Recommendation Report for Planning Permission for Works or Extension to a Dwelling

REF NO: R/176/20/HH

LOCATION: 6 Ruston Avenue
Rustington
BN16 2AP

PROPOSAL: Erection of new 1.8m high garden wall to side frontage facing Ruston Avenue

DRAWING:
PROPOSED LOCATION PLAN, BLOCK
PLAN, SITE LAYOUT & ELEVATIONS

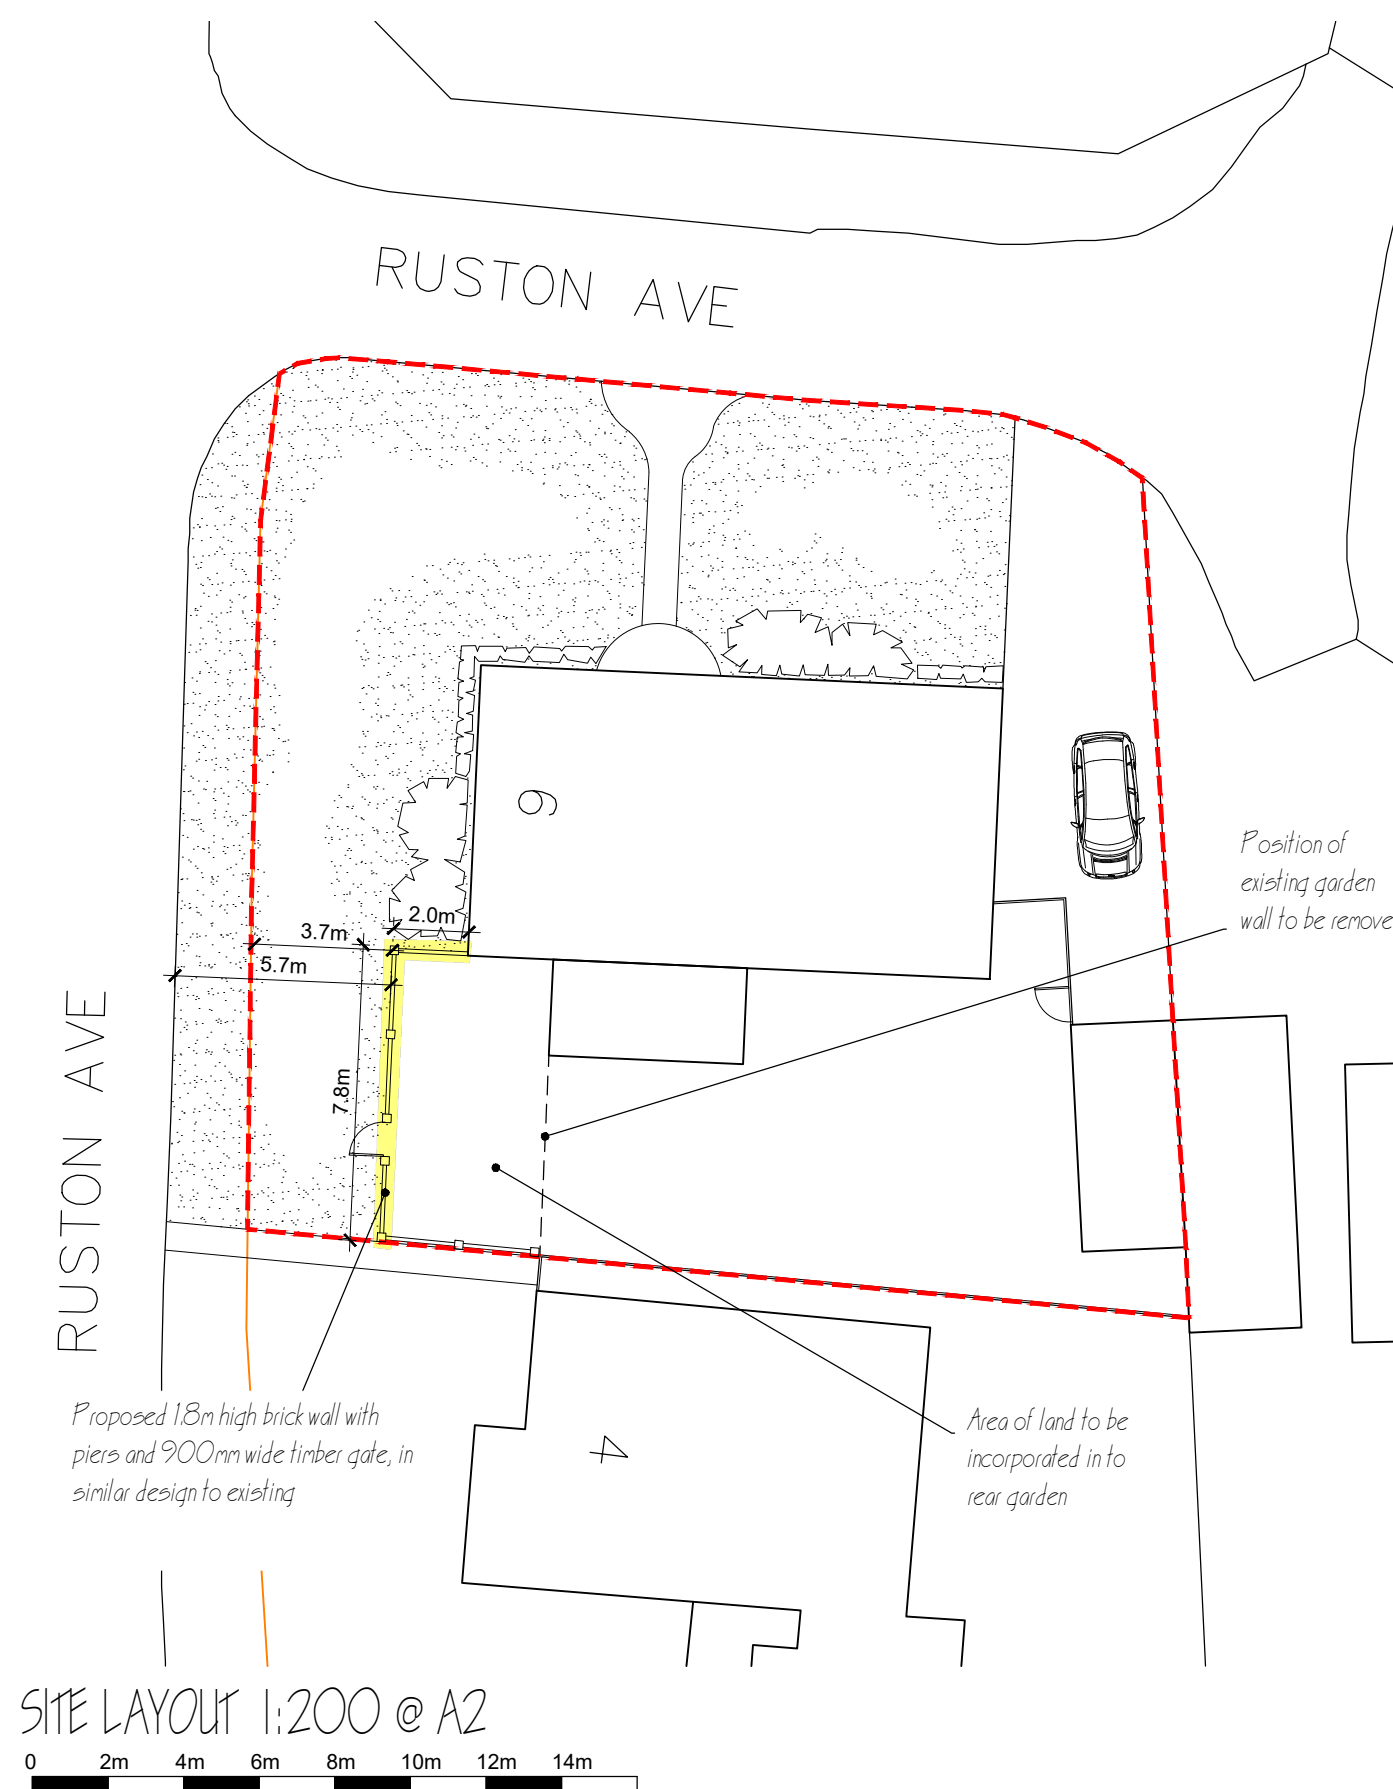
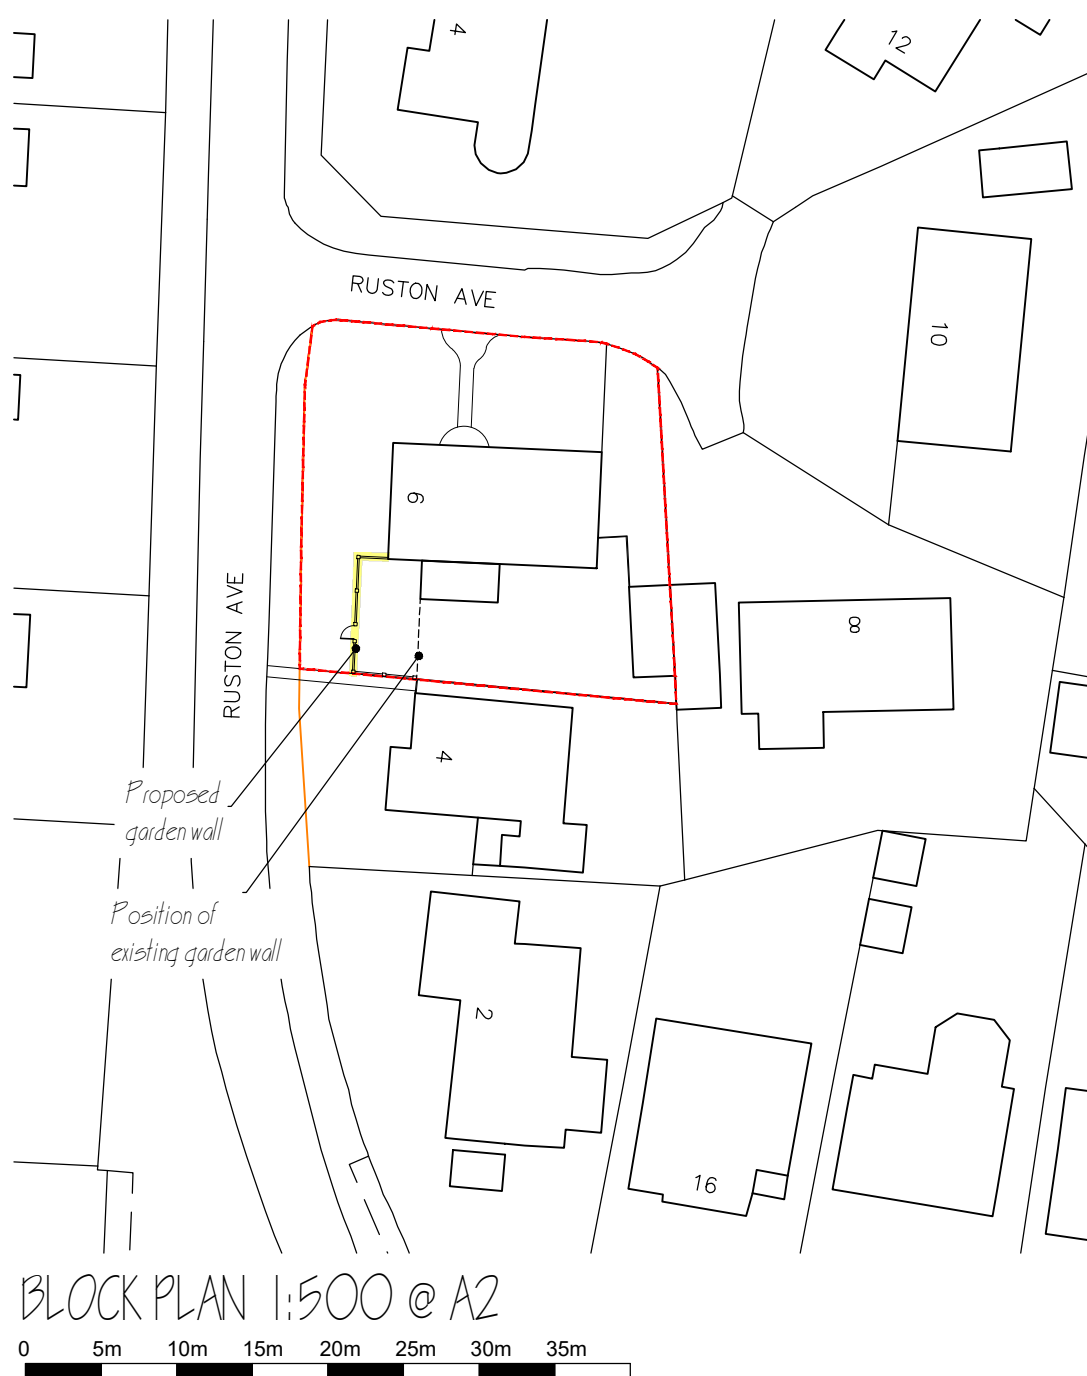
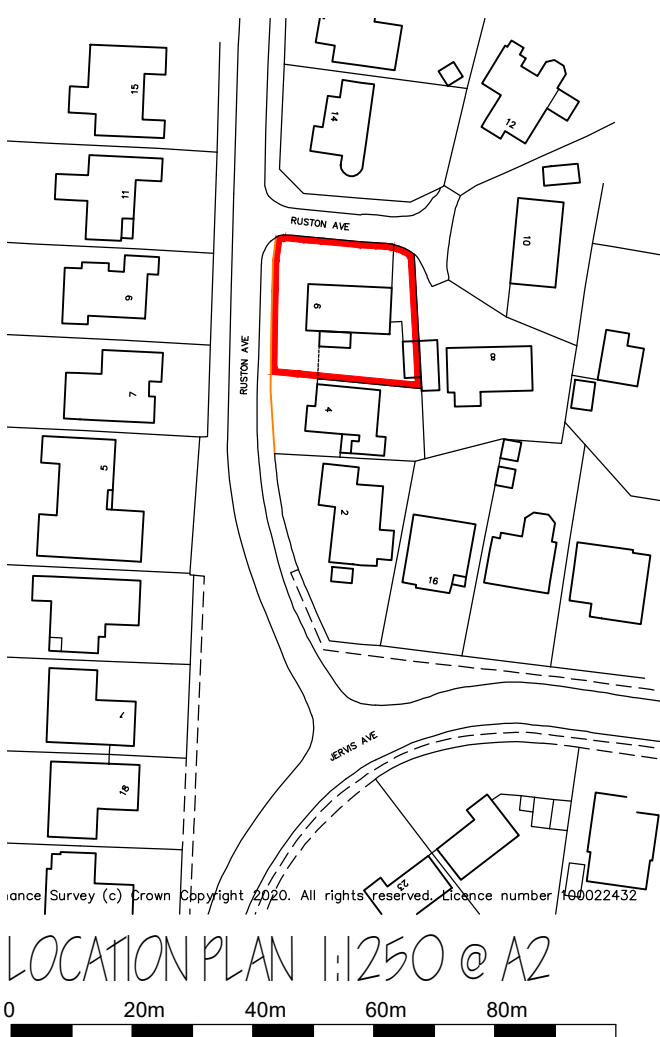
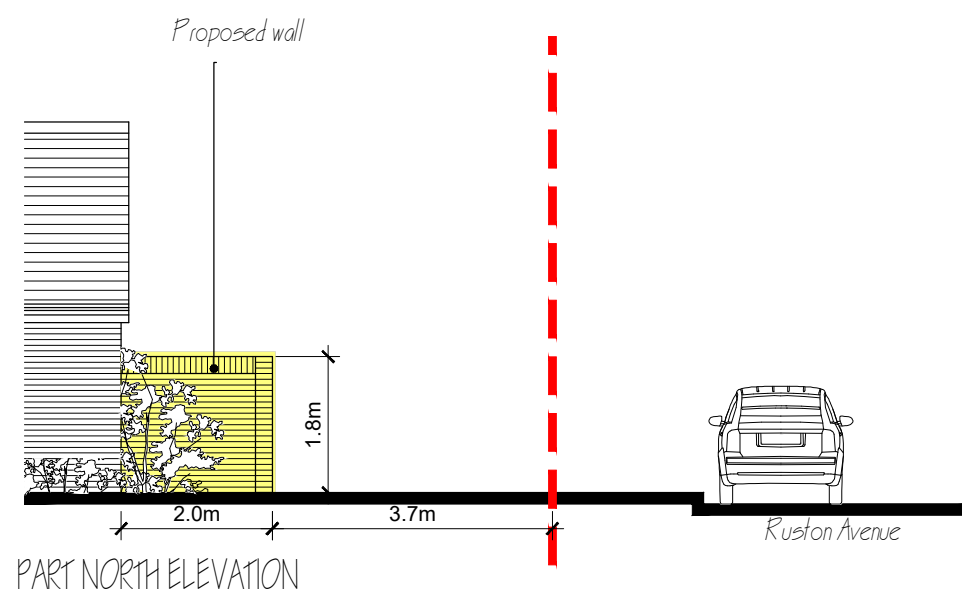
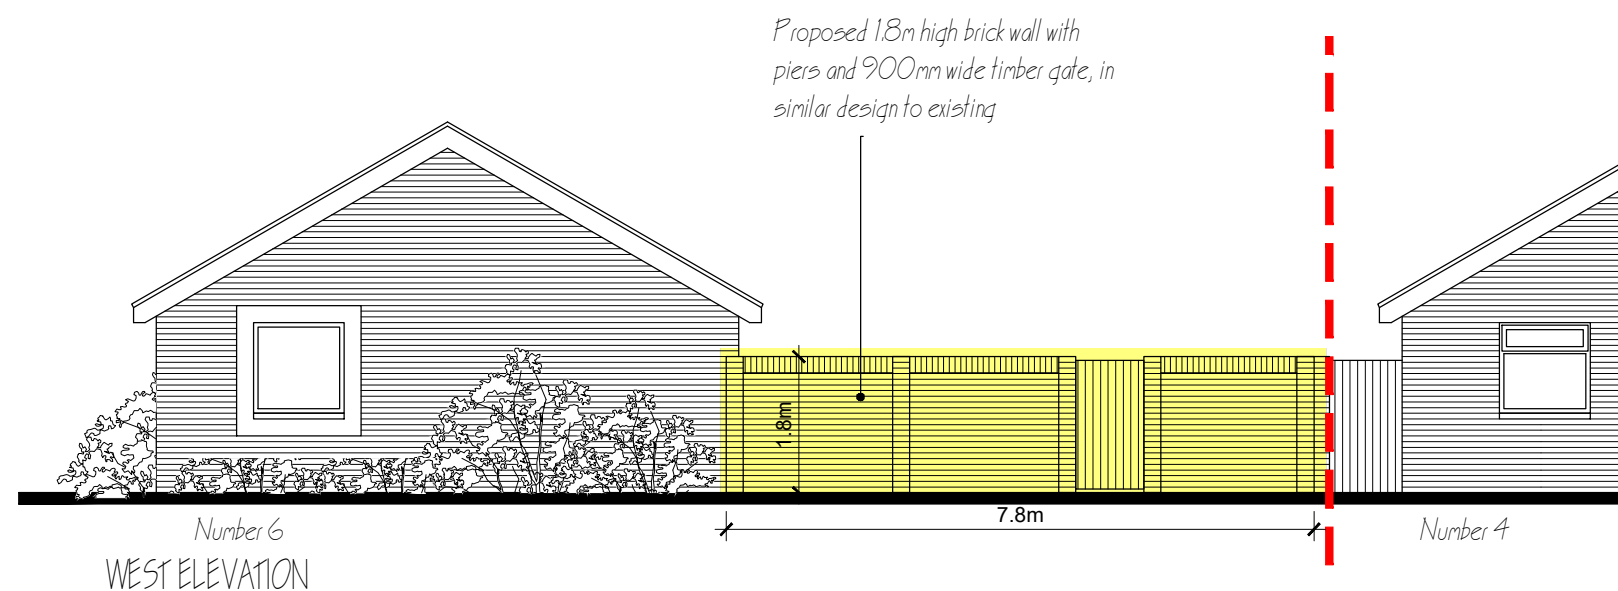
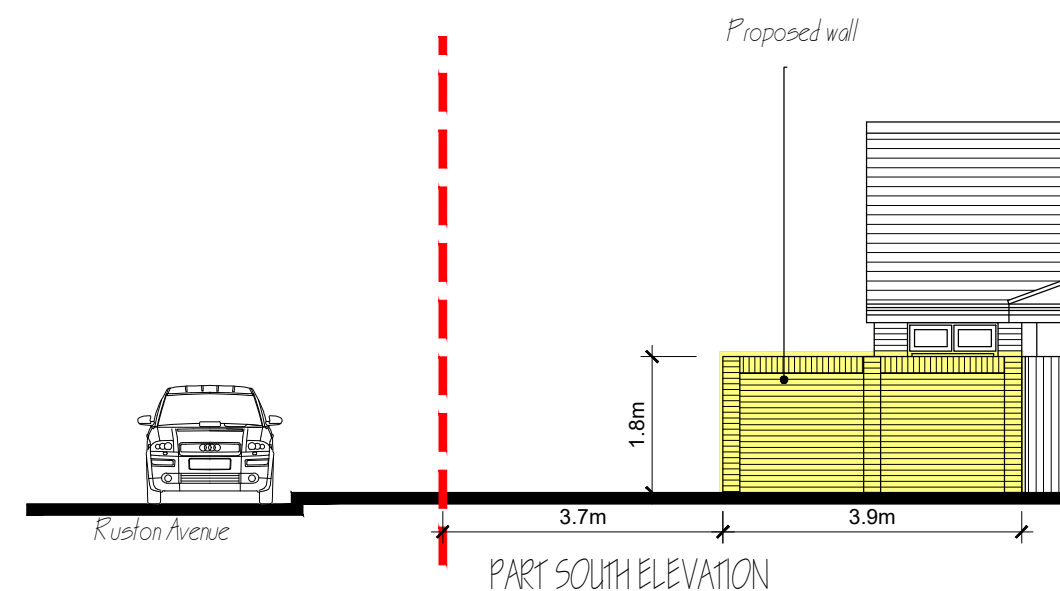
- Wall comes within 50mm of inspection cover.
- There are no details of subgrade.
- The wall will block the view down the road from the living room of the neighbouring dwelling.
- The wall has a harmful impact upon the character and environment of the area.
- The plans are inaccurate.

Whilst it is noted that the area is of an open character, there is an existing boundary wall, of which the proposed wall replaces in order to afford the dwelling additional private amenity space. The proposal will be of materials to match the existing wall, of the same scale and of a similar design. The wall is approximately 4m closer to the street scene and 2m closer to the street scene than the host dwelling. To site this wall 2m closer to the street scene does not result in any additional material harm, compared to that of the existing wall of the host dwelling.

The proposed boundary wall is sited over 5m from the roadside in the area, and is of a design of which is similar to that existing. As such, whilst the wall may have a visual impact on the character of the area, in that it brings forward the existing boundary treatment for the host dwelling it is not considered to be significantly harmful, given the use of matching materials, and an acceptable distance retained to the street scene itself.

Comments noted. Planning considerations raised will be addressed in the conclusion sections. The plans become the approved plans following the decision of the application, and as such, the proposal must be built in accordance with these.
